**Subject:** RE: Planning Consultation on: LU/145/21/PL

Please see comments below from Private Sector Housing concerning the change of use from a dwelling house to a 9-bed HMO.

**Site Address:** 12 Cornwall Road Littlehampton BN17 6EE

**Description of Works:** Change of use from (C3) Dwelling house to 9 bed House in Multiple Occupation (Sui Generis)

Date April 2021	Drawn By JM	Scale 1:50 @ A1
CAD file name 12 Cornwall Road - PLANNING Rev01.dwg		
Drawing No 2350-P-02	Revision A

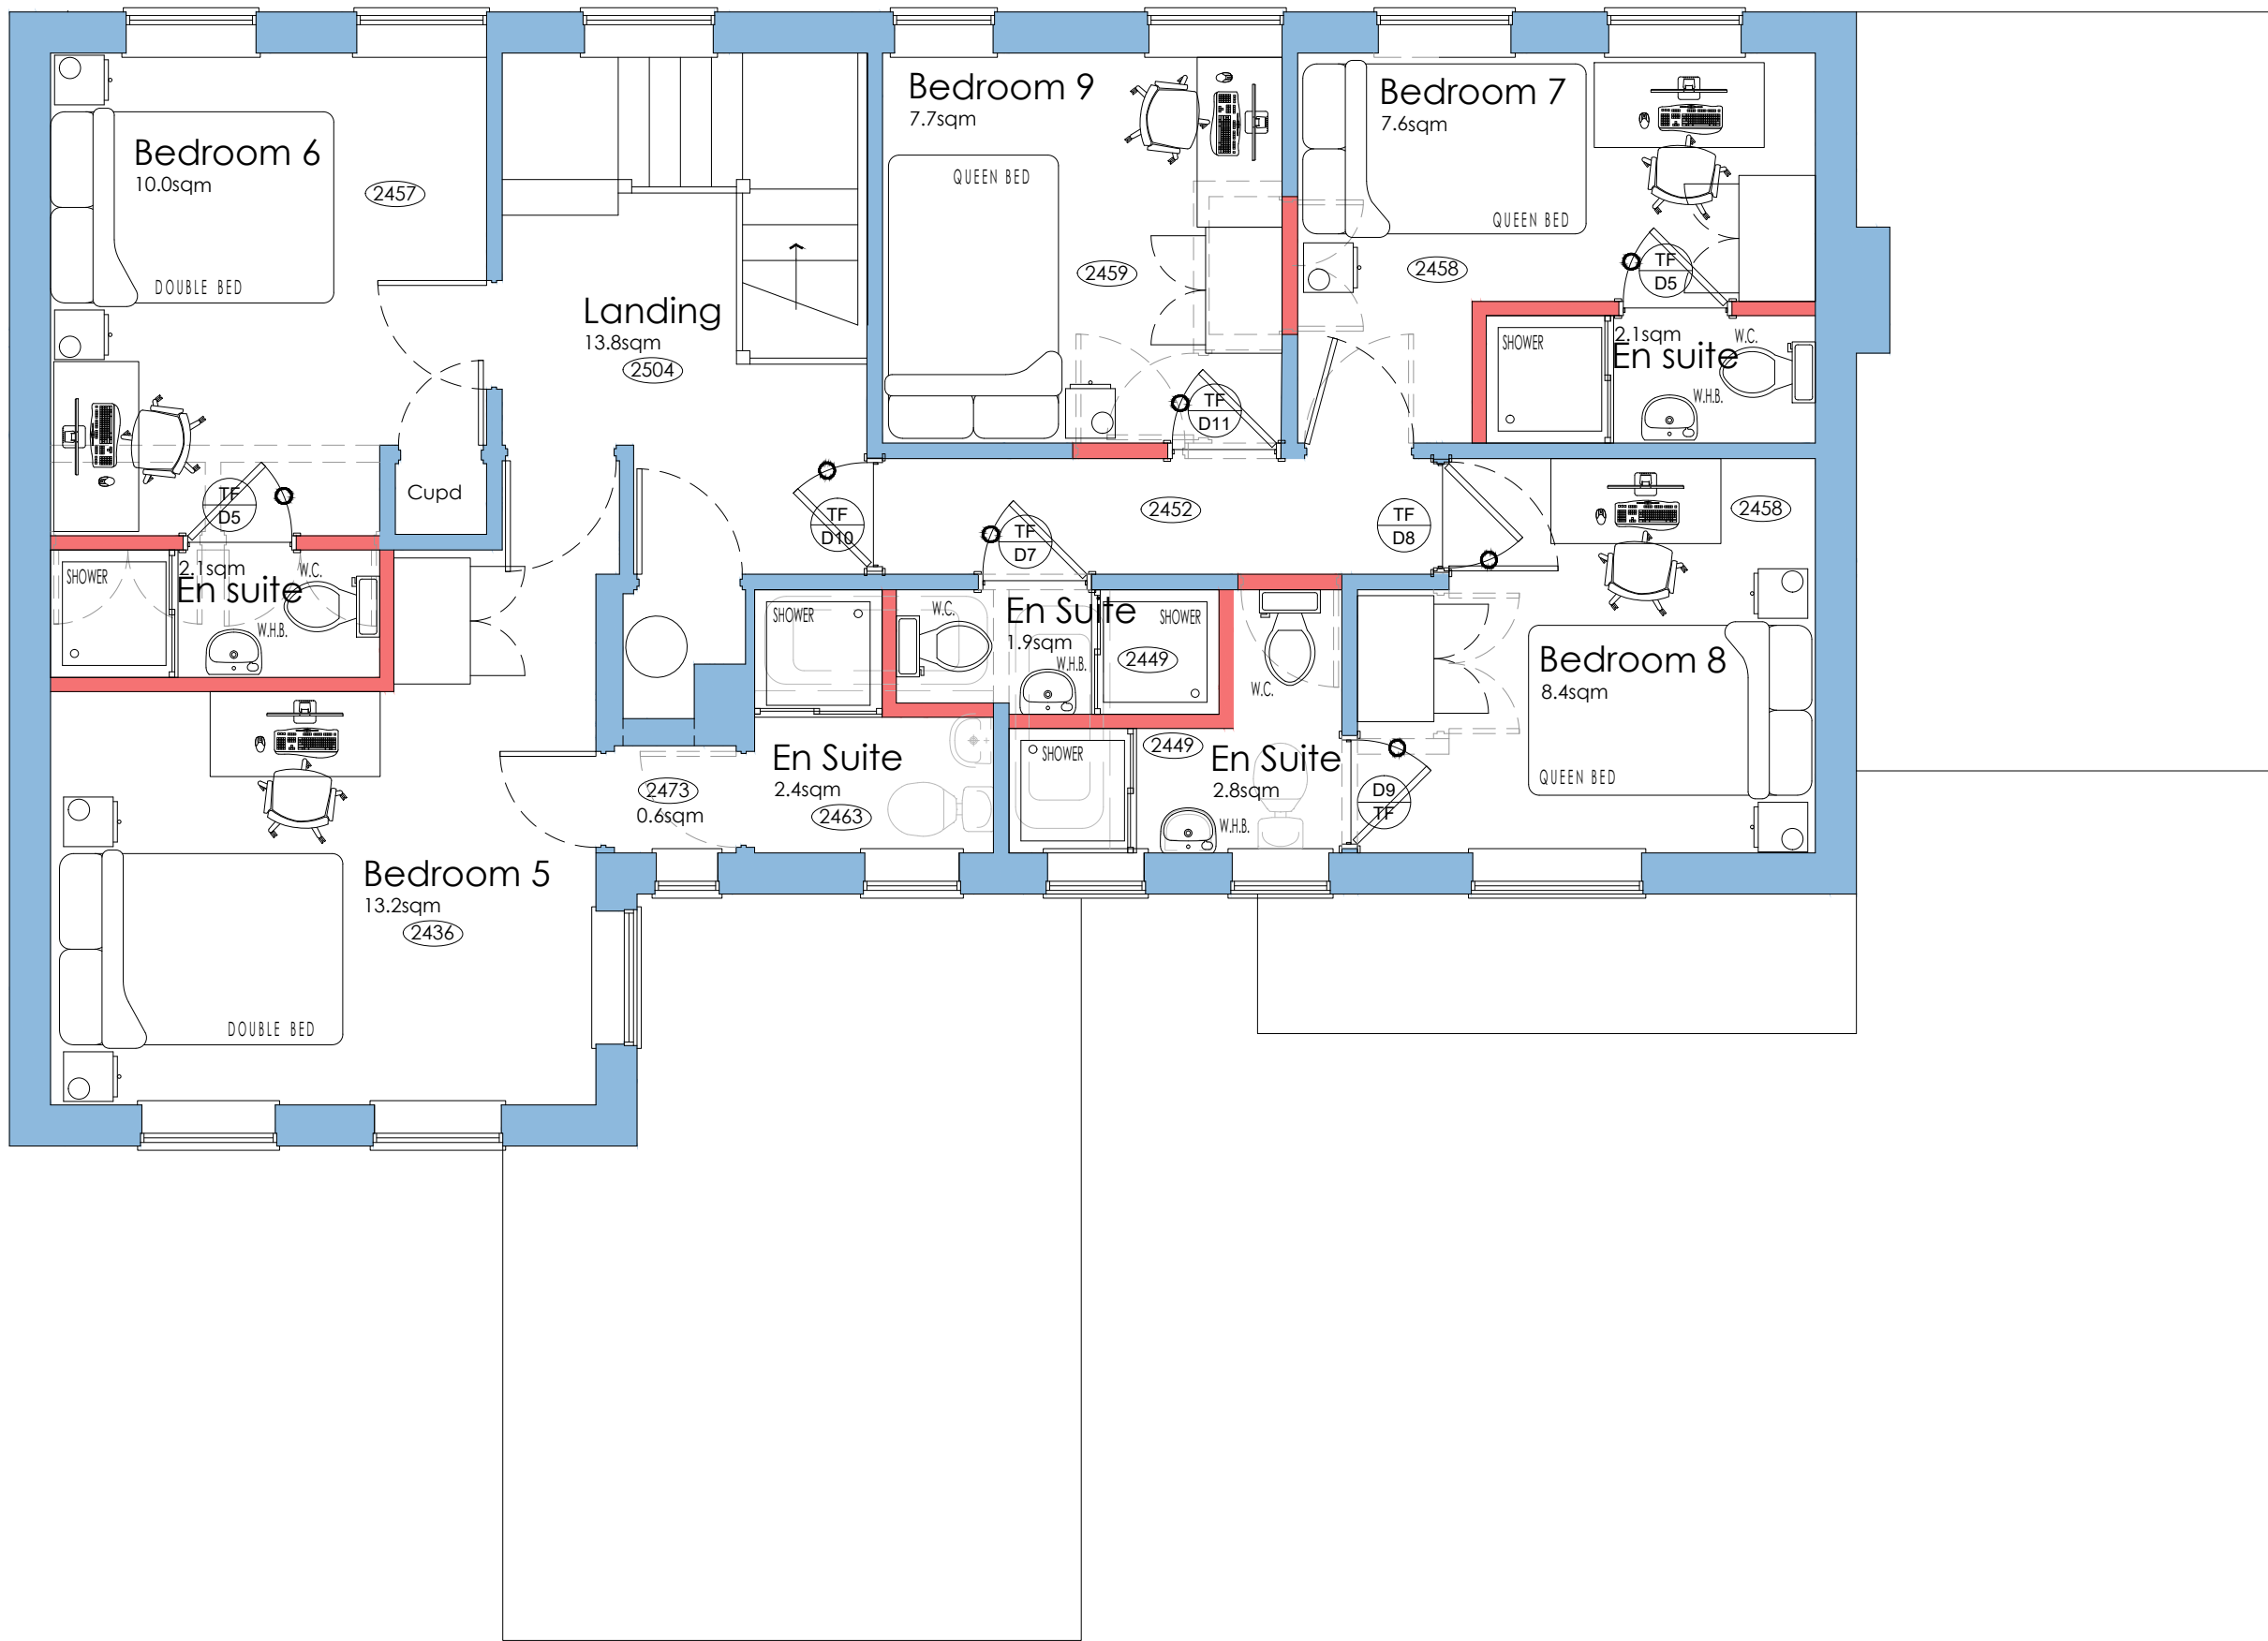
- Assuming the bedrooms are intended for single-occupancy use, the shared kitchen is too small for 9 occupants as it must be a minimum size of 13m<sup>2</sup>. N.B. This measurement is based on the kitchen being used for cooking only with separate communal dining facilities elsewhere, as proposed in the plan. However, if the kitchen is to increase in size, this will result in the shared lounge and shared dining room being undersized. One way to overcome this would be to extend the kitchen to create a kitchen/diner. The minimum size required for this, based on 9 occupants, would be 17.5m<sup>2</sup>. N.B. If appropriate communal dining facilities are not provided, either via a kitchen/diner or a separate lounge/diner, the minimum bedroom sizes for single-occupancy will increase to 10.2m<sup>2</sup>, which will result in several bedrooms being undersized.

- The proposed layout of the kitchen does not appear to provide the correct amenities. For example, based on 9 occupants, the following would be required (this is not an exhaustive list):

- 2x sink and drainer units (a dishwasher could be considered as an alternative to a second sink)
  - 2x ovens with 4 ring hob and grill (a combination microwave oven could be considered as an alternative to a second oven)

- Minimum 500mm (L) x 600mm (D) worktop per user – smaller lengths less than 500mm cannot be counted towards the overall requirement)

- The ensuite bathrooms to bedrooms 2, 4, 6, 7 and 9 do not appear to be of an adequate size or layout. The bathrooms must be of an appropriate size to provide adequate changing and drying space for the users. The proposed plans show these ensuite bathrooms to be of the same width as the shower tray and with very limited space as the wash hand basins, WC units and shower trays appear to be in close proximity to one another. If a person were to use the ensuite bathroom in bedroom 6, for example, it is likely they would step out of

the shower cubicle and immediately collide with the wash hand basin, as well as colliding with the walls either side of them when attempting to dry themselves or get changed. In addition to not meeting the HMO Standards, this is likely to be identified as a hazard under the Housing Health and Safety Rating System (HHSRS).

- within the shared kitchen
- within the shared dining room (if this remains open to the shared kitchen)
- Fire blankets should be provided to all kitchen areas
- If egress from bedroom 4 is via the shared lounge, bedroom 4 will be considered an inner room. The external door within bedroom 4 must be openable without the need for a key, e.g. a thumb turn lock, and lead to a place of ultimate safety.

- The ensuite bathroom to bedroom 5 appears to only comprise a shower cubicle. If this is correct, a wash hand basin must also be provided; please refer to Arun's HMO Standards for the minimum size requirement for wash hand basins. It is also assumed that the separate WC compartment located on the ground floor will be for the sole use of bedroom 5.

- It is not clear if the entrance door to bedroom 4 is via the shared lounge. If this is not an access door between the two rooms and bedroom 4 is to come and go via the external door only, it is not reasonable to expect the occupant to exit the building and re-enter elsewhere in order to use the communal facilities.
